STATE OF WASHINGTON  
DEPARTMENT OF ECOLOGY

May 3, 2021

Re: SEPA Register 202102026, SE-21-00007

Thank you for the opportunity to comment on the Pre-Threshold Consultation for the Spring Creek Restoration Project, proposed by Kittitas County Public Works. We have reviewed the environmental checklist and have the following comment.

Figure 1: Proposed Restoration Planting Zones

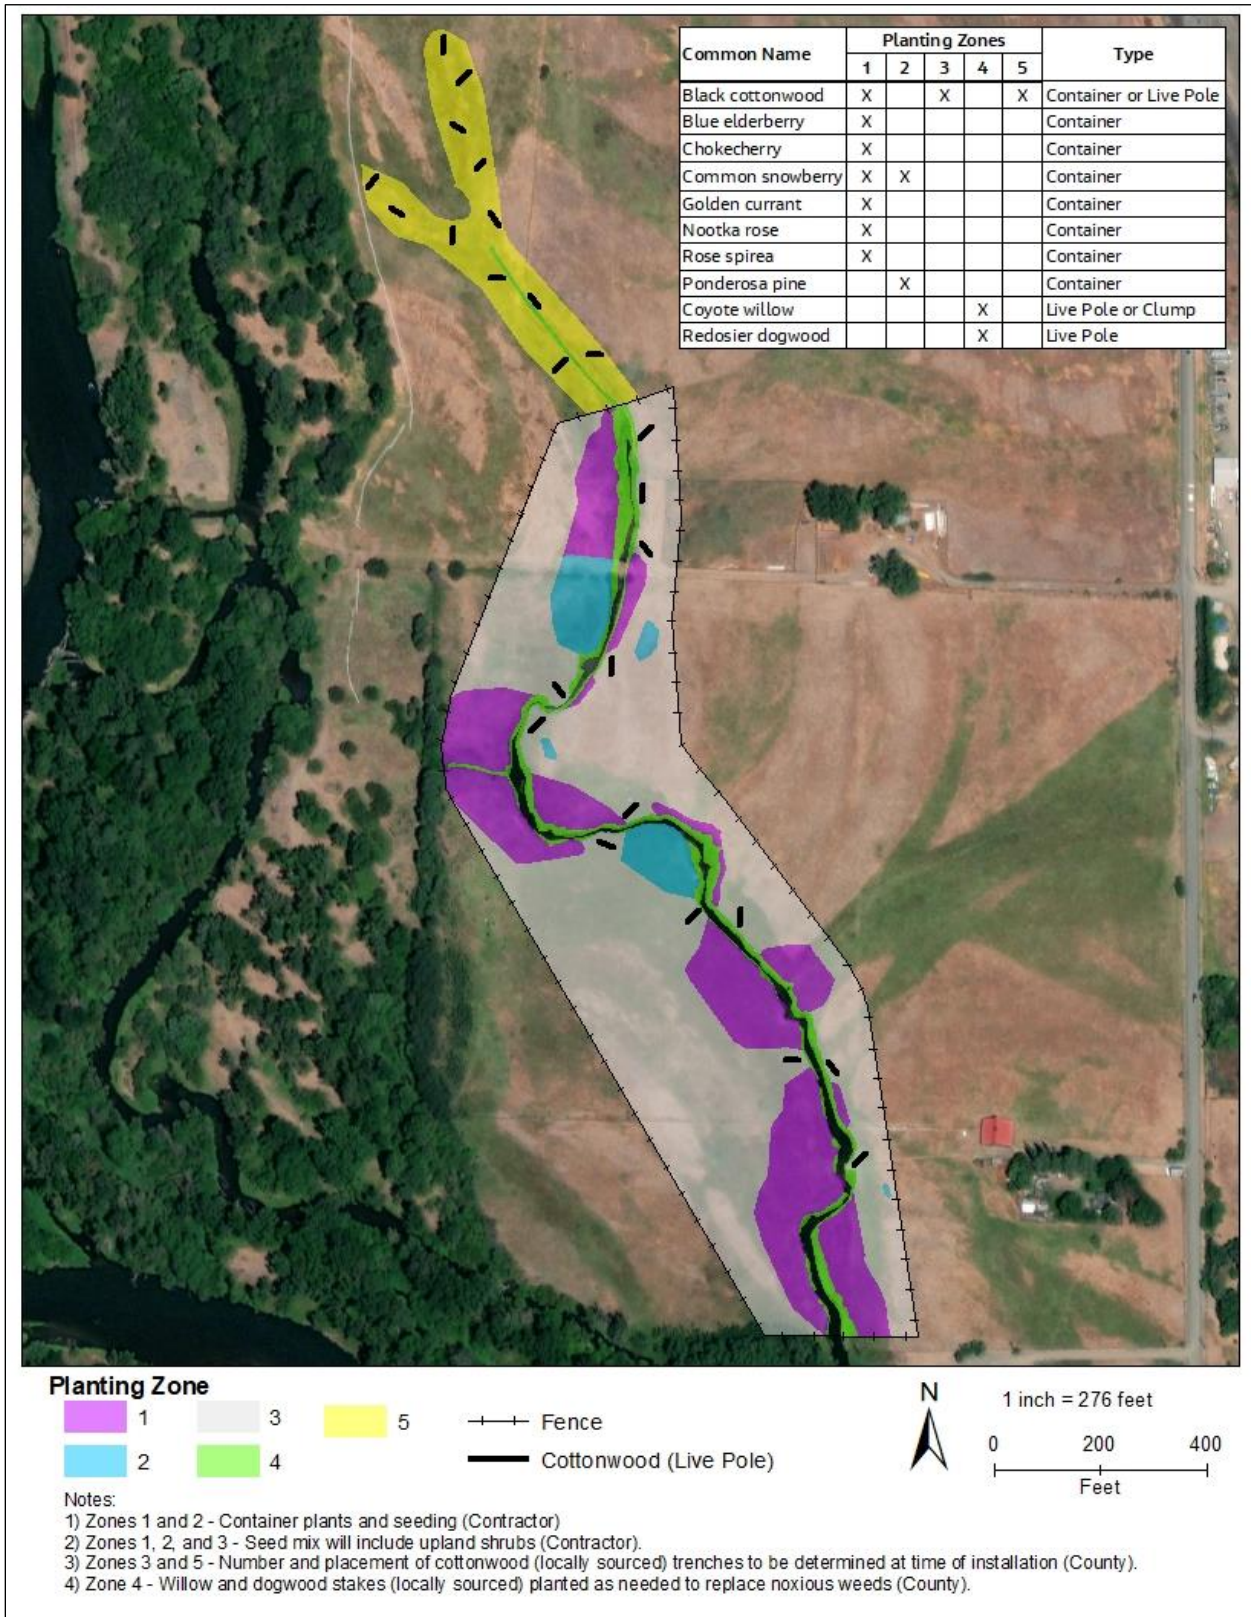
It was noted within the SEPA Checklists that planting of the overgrazed land will be beneficial. It is unclear if livestock have been removed from the project area. Ecology recommends all livestock be excluded from the newly planted area by fencing, if possible.

Figure 2. Delineated OHWM and Wetlands

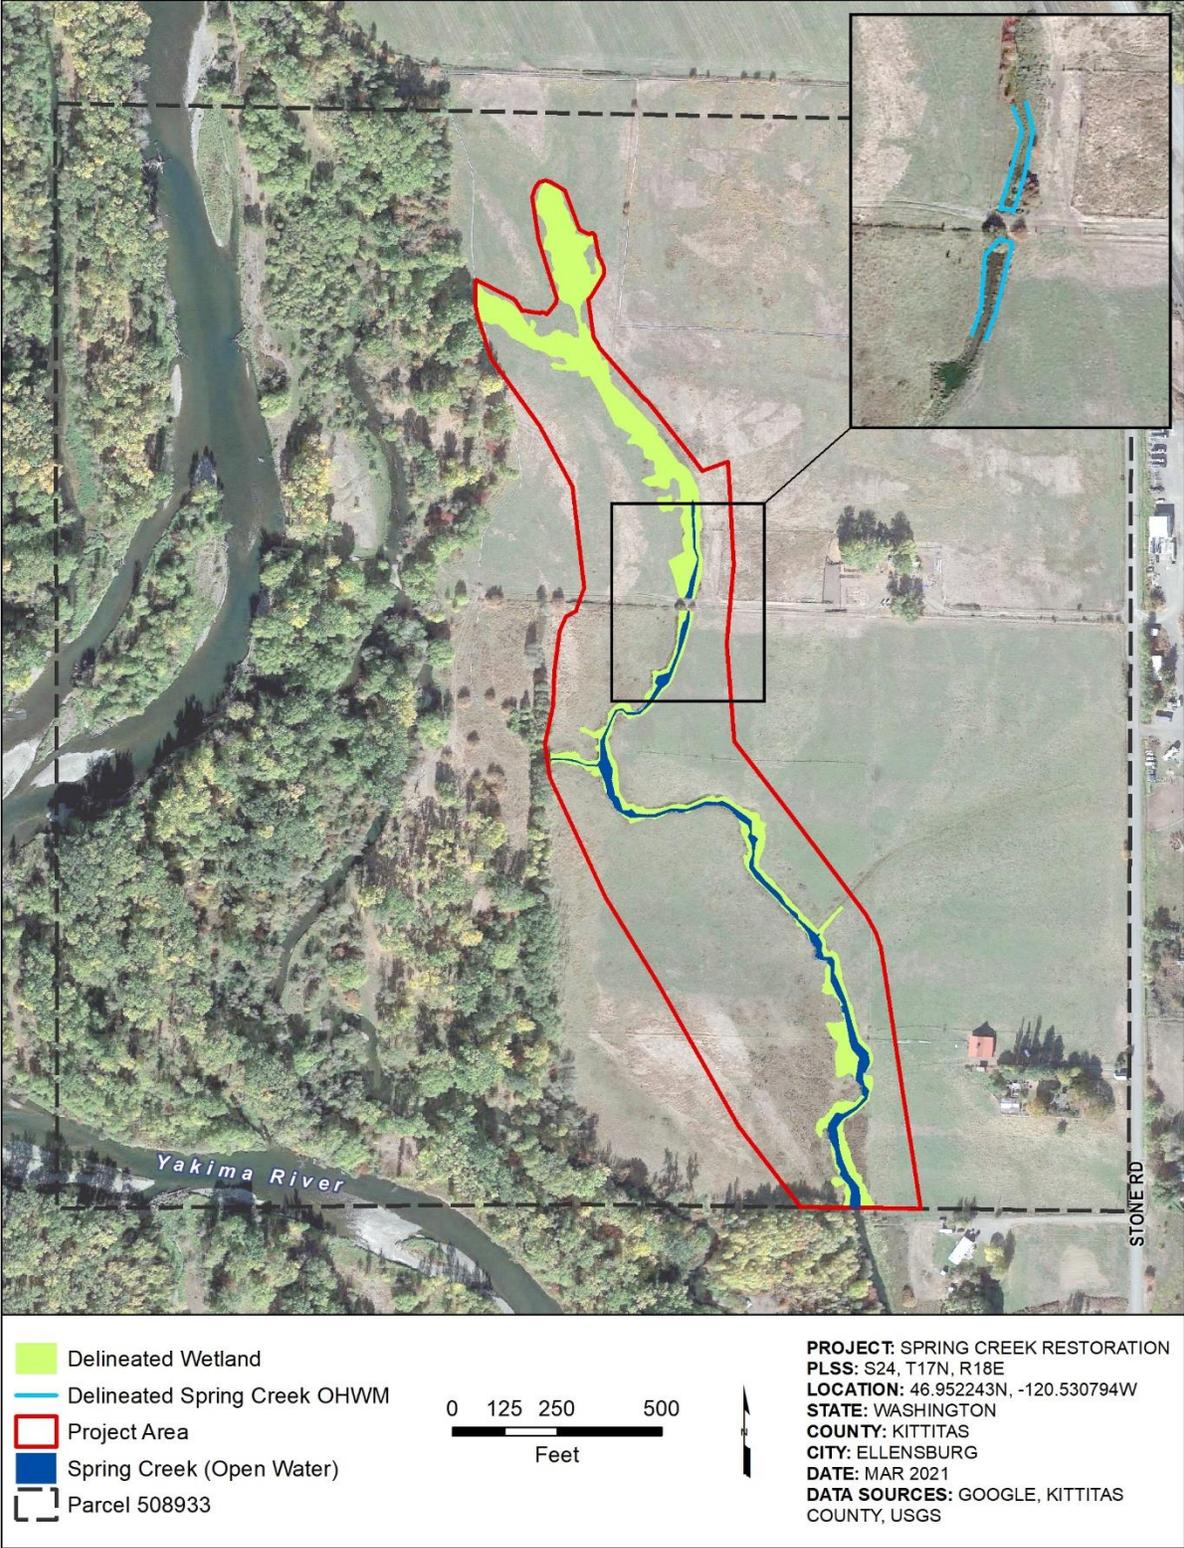
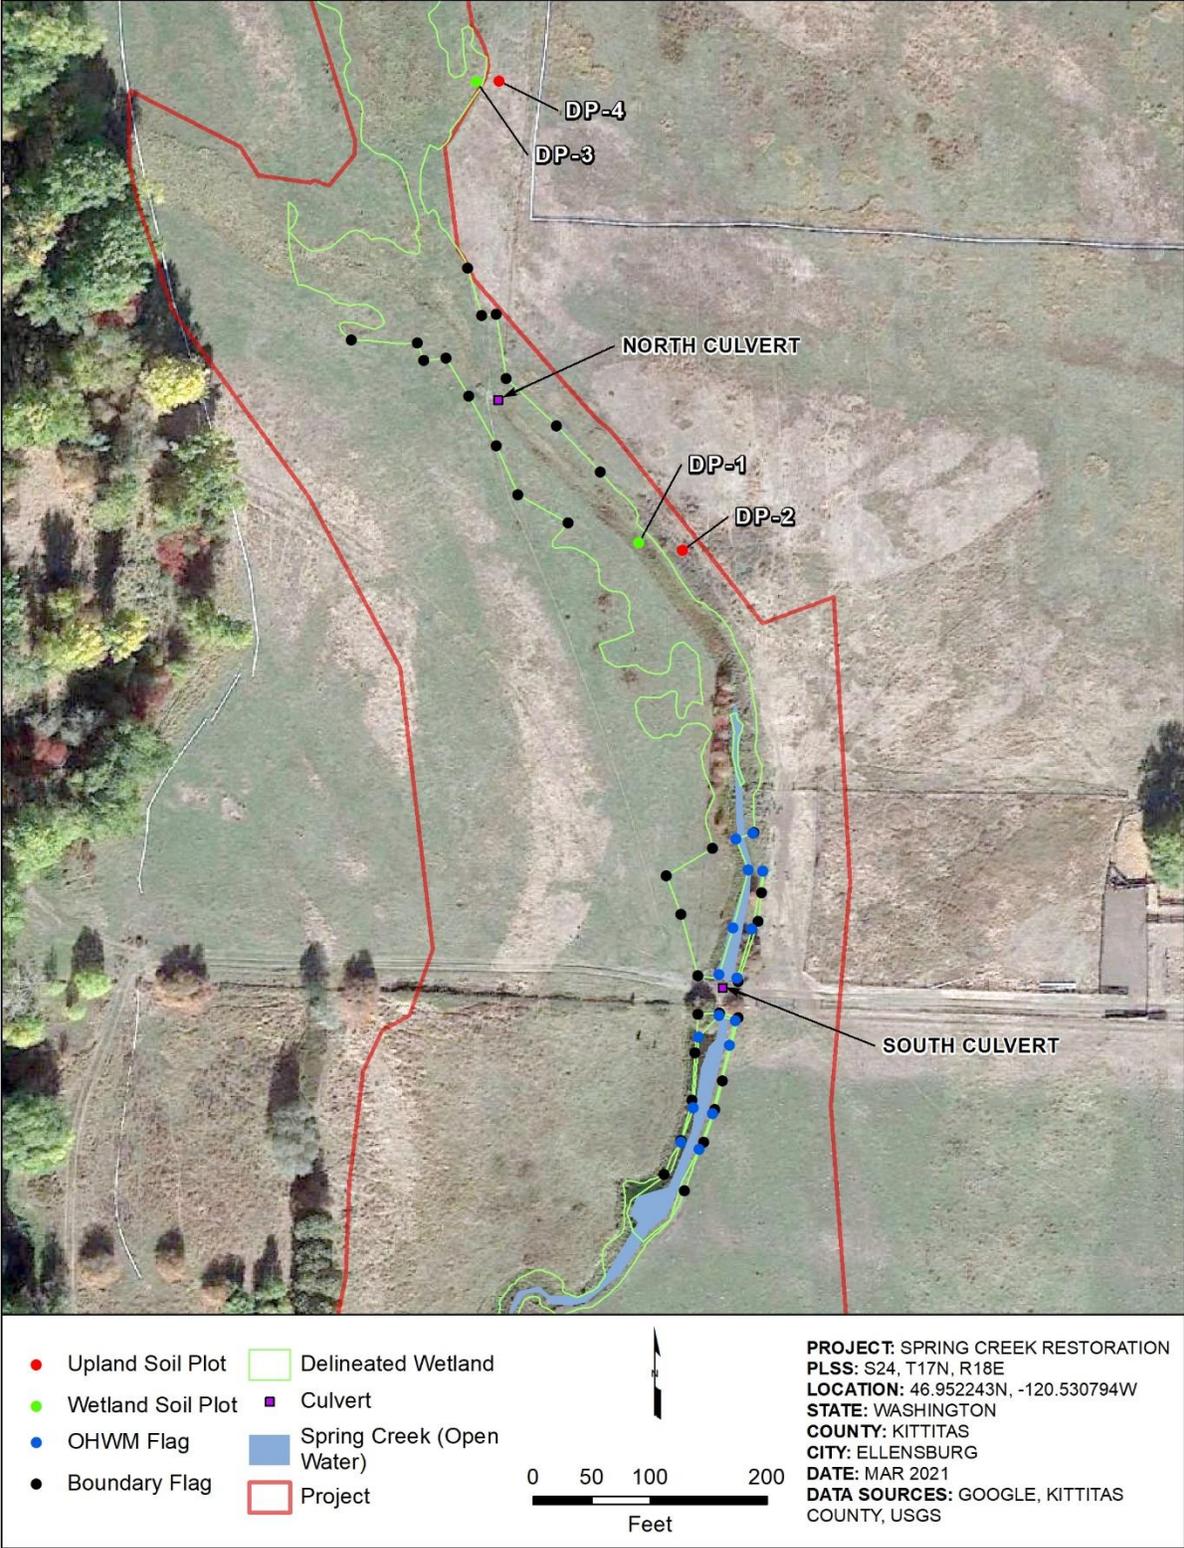
A 2.77 acre Category III wetland is reported to existing within the project site and surrounding Spring Creek. A wetland delineation and rating need to be included within any permit application to be deemed complete. Ecology staff have not had an opportunity to review a wetland delineation and rating for this project site. We request a copy of the documents be submitted to ensure correct methodologies were used to make the determinations of the wetland boundary location and category of wetland.
